From: Martyn White <Martyn.White@arun.gov.uk>
Sent: 18 November 2019 14:11
To: Planning.Responses <Planning.Responses@arun.gov.uk>
Subject: CM/53/19/PL

CM/53/19/PL

Proposed Site Plan 1:200@A3

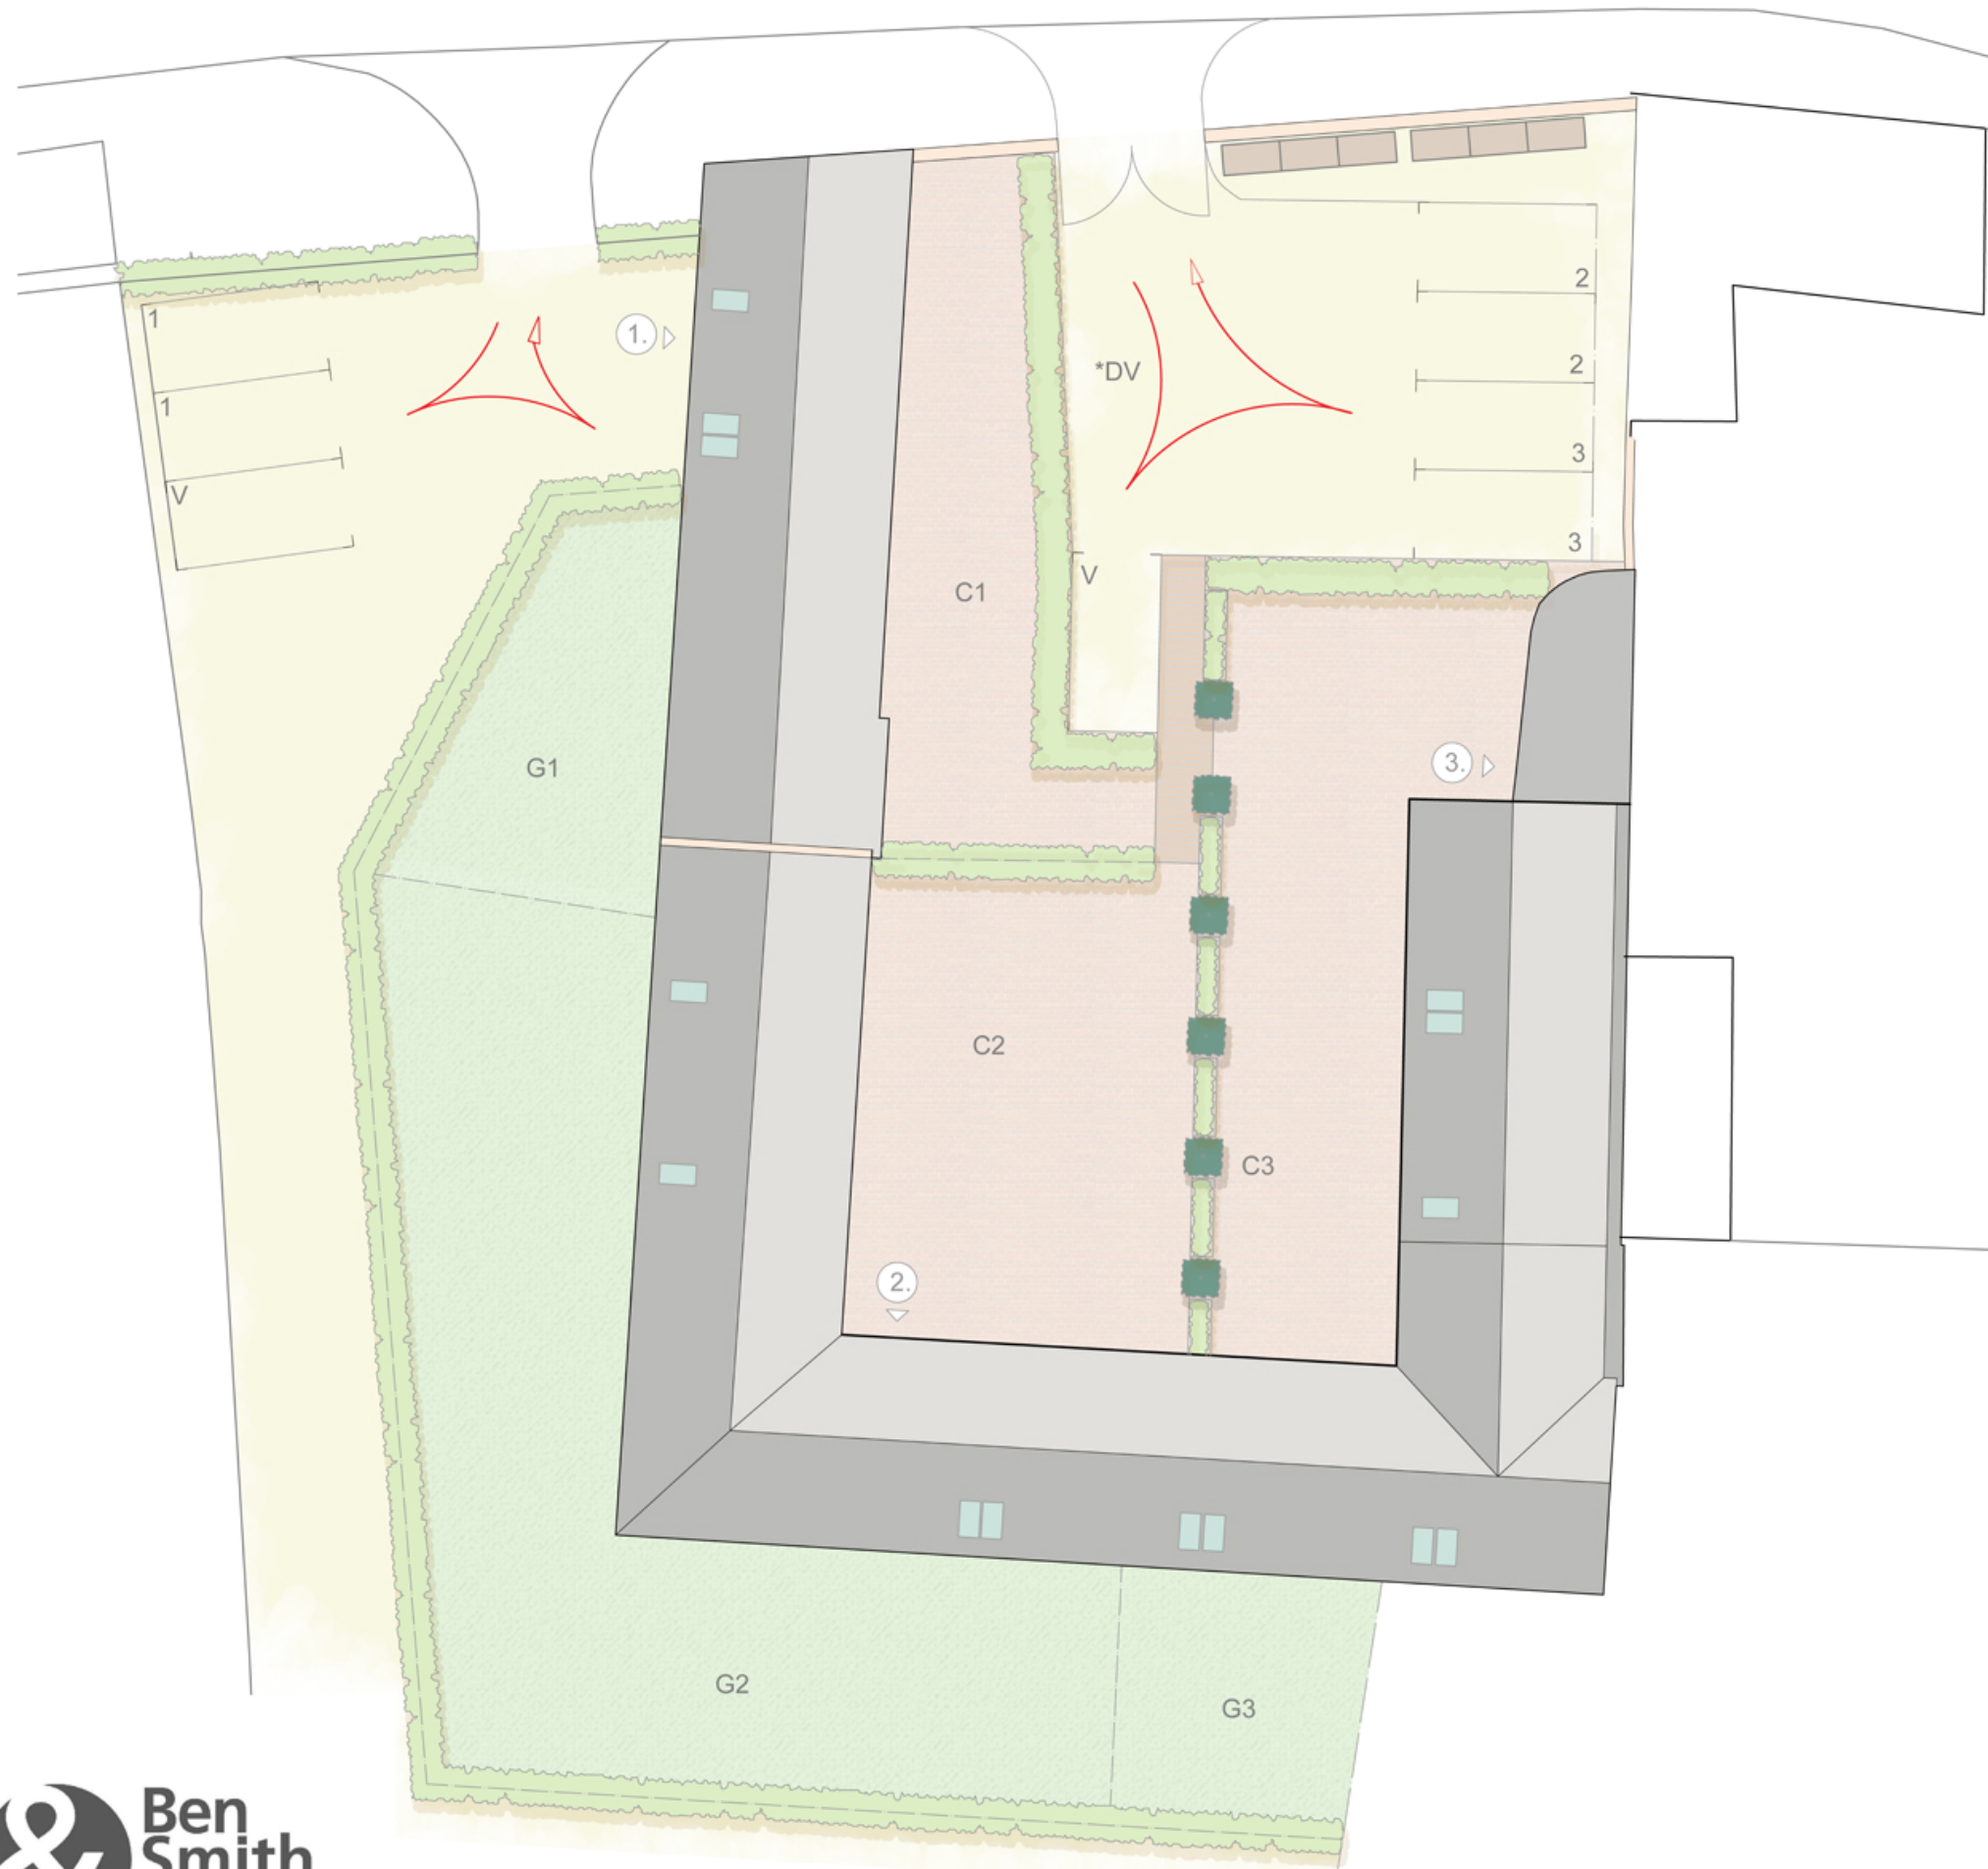
However, it is disappointing to see that the courtyard is to be sub-divided up into a series of smaller spaces. This is contrary to the concept of the space having been used as an agricultural courtyard space, and will have a negative impact upon the established character of the building and its context. It is important to note that a neighbouring courtyard space at Kent's Farm, remains open and used for parking. It is considered that this courtyard should maintain an open character when redeveloped, so that it maintains the character of the local group of heritage assets.
